Flying Horse North – Phase 2 PUD Parcels 1-6 Preliminary Drainage Report

November 2023

PCD File No. PUD-XXXX **PUDSP234**

EPC STORMWATER REVIEW COMMENTS
IN ORANGE BOXES WITH BLACK TEXT

SHEET  
**EX**  
 1

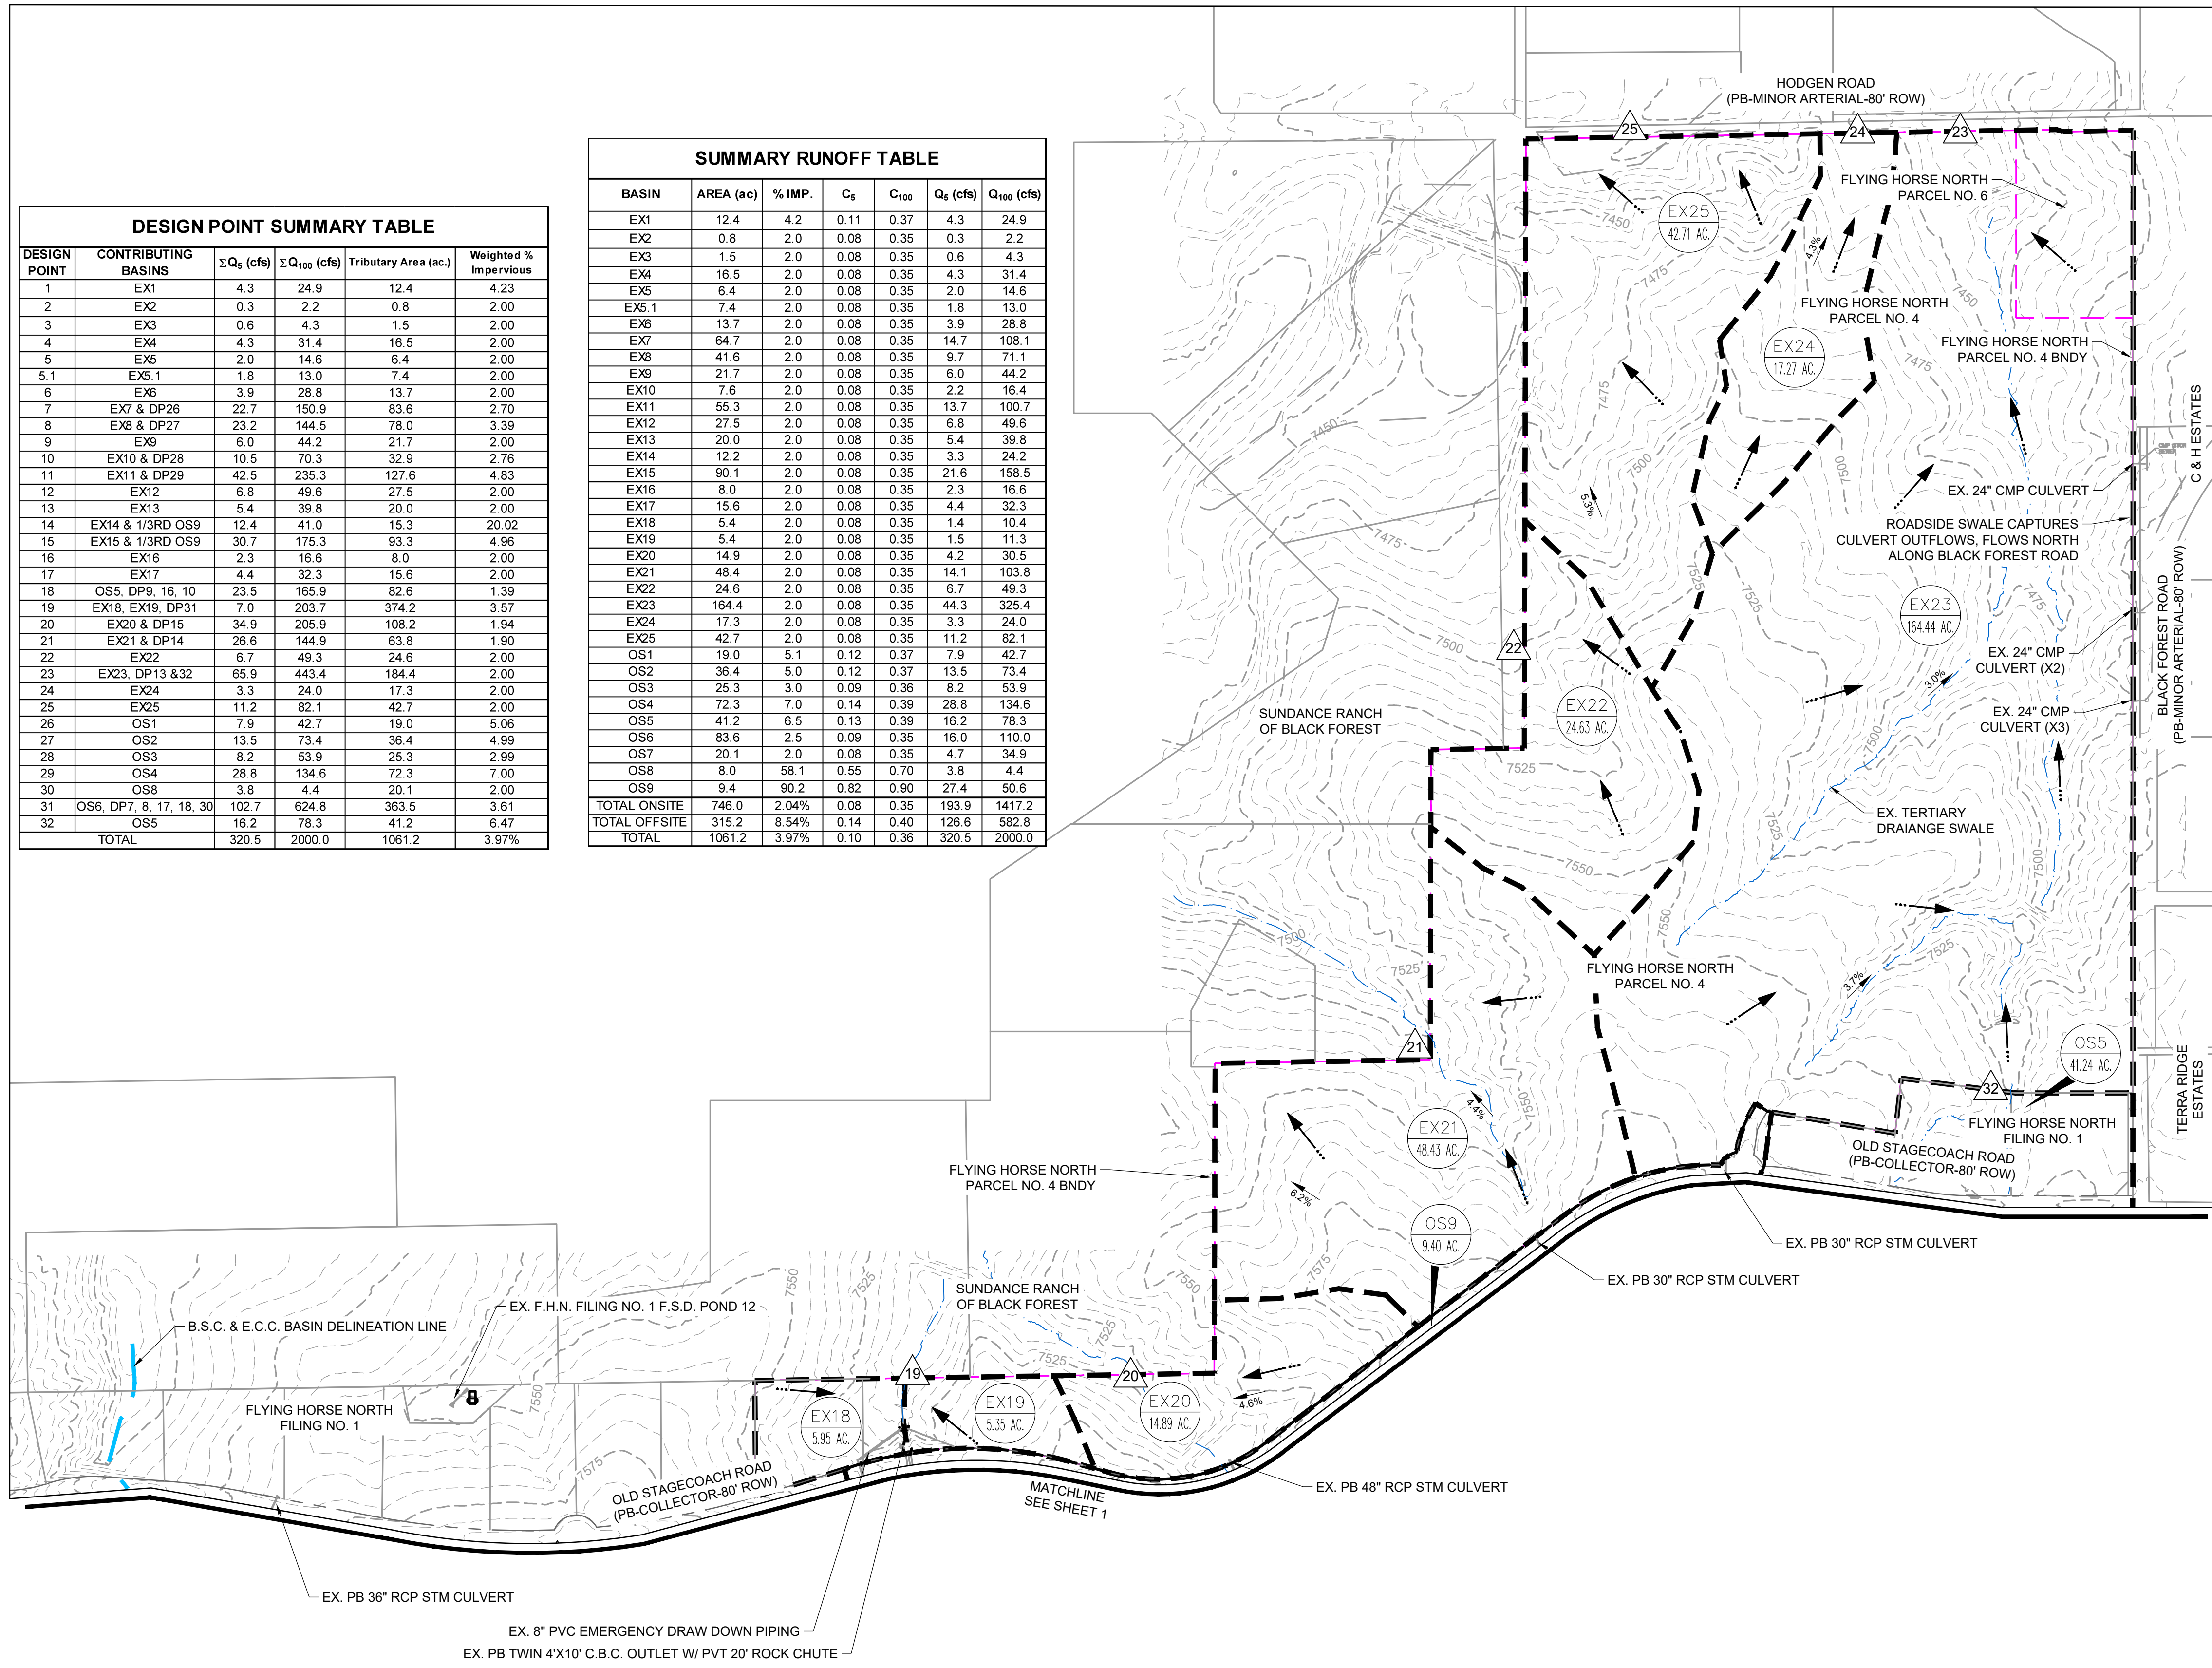
please label pond 12
on the drainage map.

Verify highlighted values - the drainage map
reports different flows.

Verify, drainage maps state $Q_5 = 105.7$ and $Q_{100} = 646.6$

addressed: pond 12
has been labeled in
both pr and ex maps

Addressed; Values have
been corrected
